KIRKLEES METROPOLITAN COUNCIL INVESTMENT & REGENERATION SERVICE

Reference No:	2022/62/90674/E
Site Address:	Poplar Farm, Briestfield Road, Briestfield, Dewsbury, WF12 0PA
Description:	Alterations to integral garage to extend living accommodation and alterations to parking facilities
Recommending Officer:	Nina Sayers

Officer Report

Drawing No.
2050_14_J

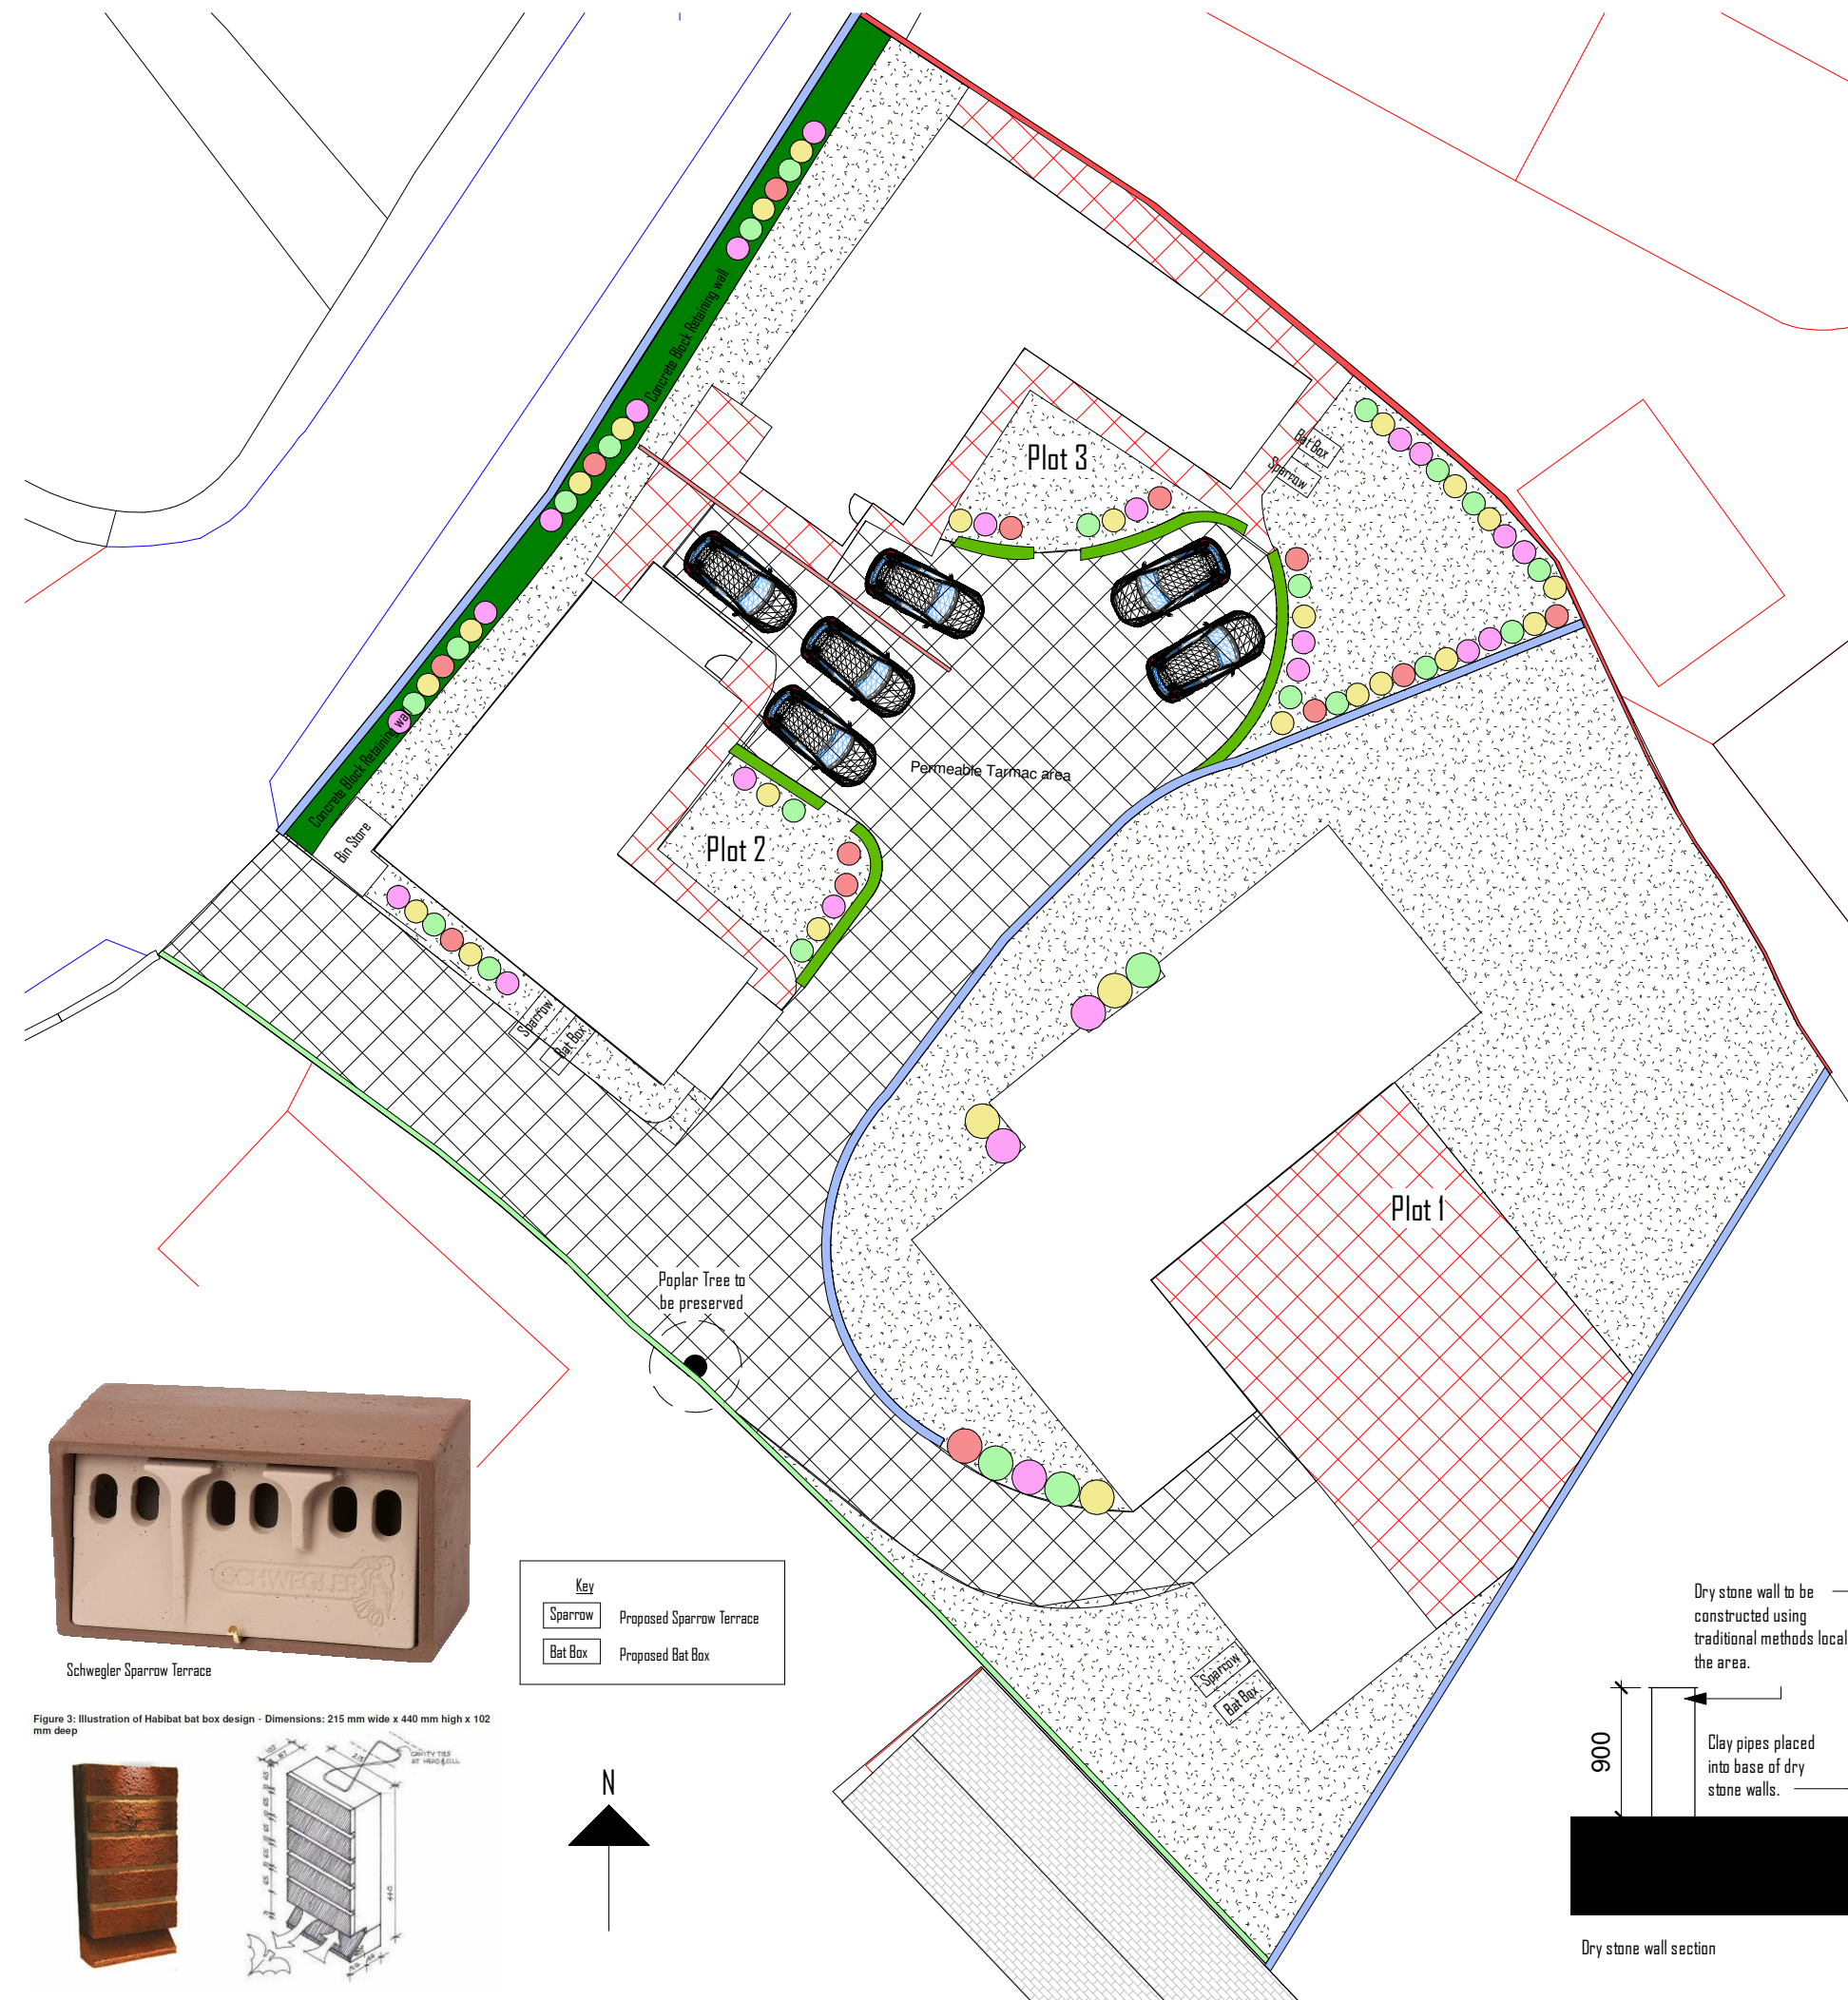
Officers had concerns regarding the layout of the proposed driveway and lack of provision for turning area. Amendments were sought and received and considered acceptable.

The proposed development would include the removal of an integral garage which would be replaced with living accommodation. For a property of this size, three off-street parking spaces are recommended. The proposed development would include the enlarging of the driveway which would provide parking for three vehicles so is considered acceptable. Amendments were sought and provided to show adequate space for a vehicle to turn around within the site. This was considered acceptable and therefore KC Highways

Drawing No. 1541_SK02_02_C

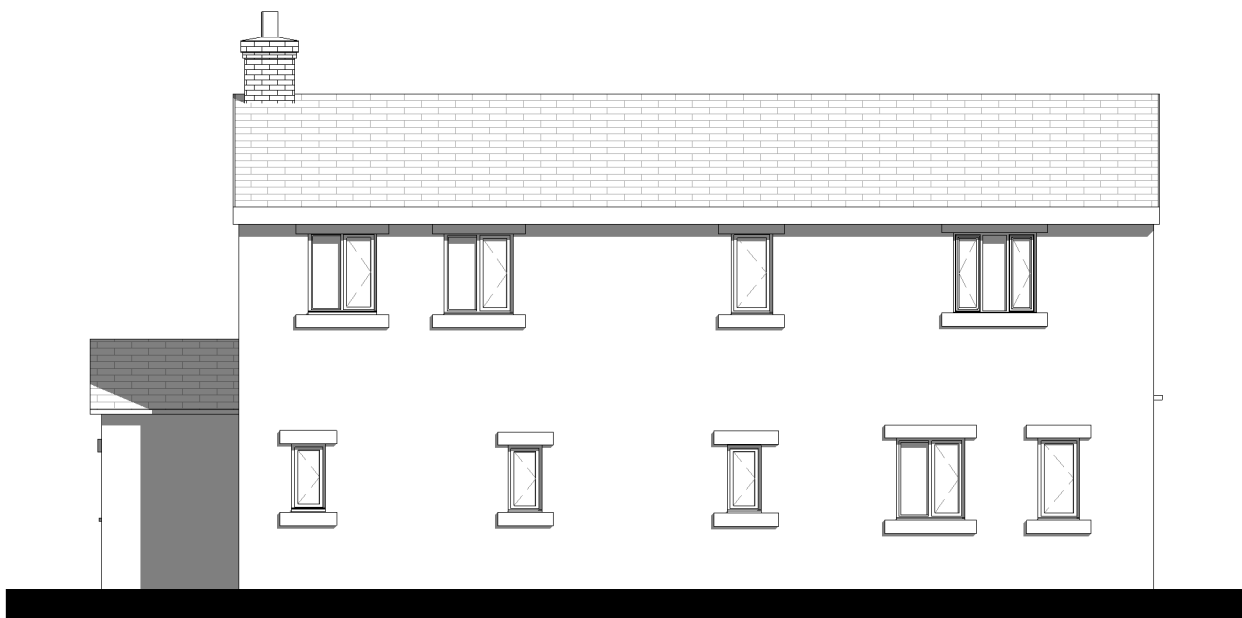
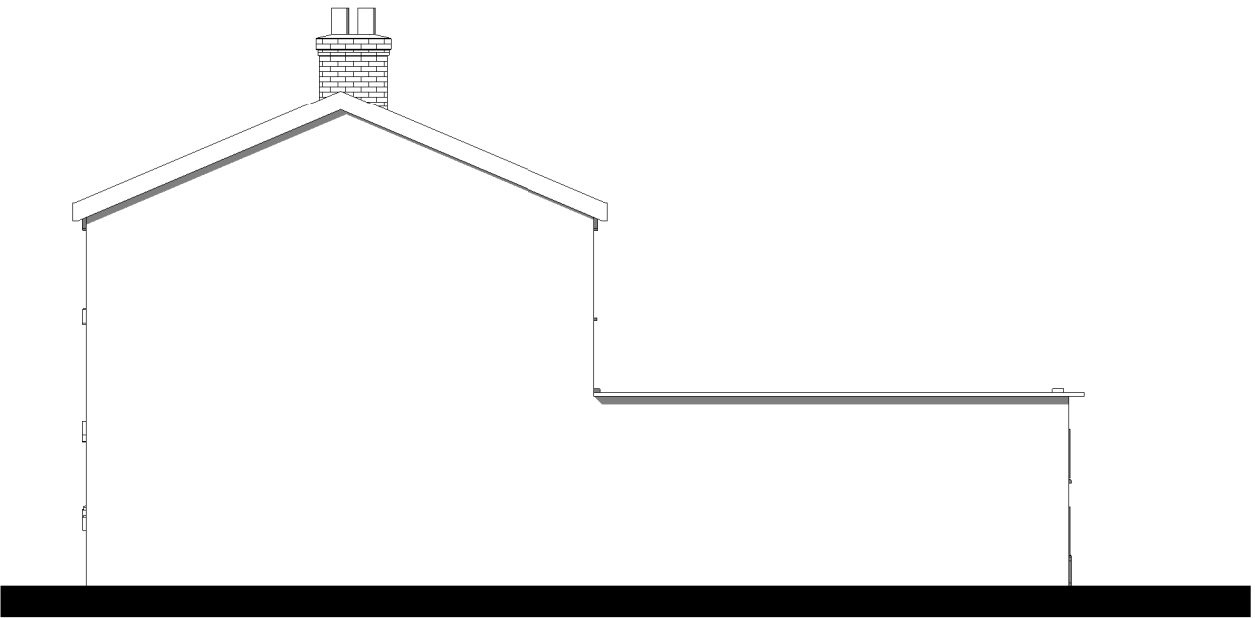
Officers had concerns regarding the design of the proposed flat roof, amendments were provided with a gable end roof, in keeping with the existing. This was considered acceptable.

The originally proposed flat roof would not be in keeping with the character of the surrounding area or the host dwelling and therefore it was requested that this was amended to a gable end roof to match the existing. Amendments were provided, with the proposed roof a gable end, as existing, this was considered acceptable.
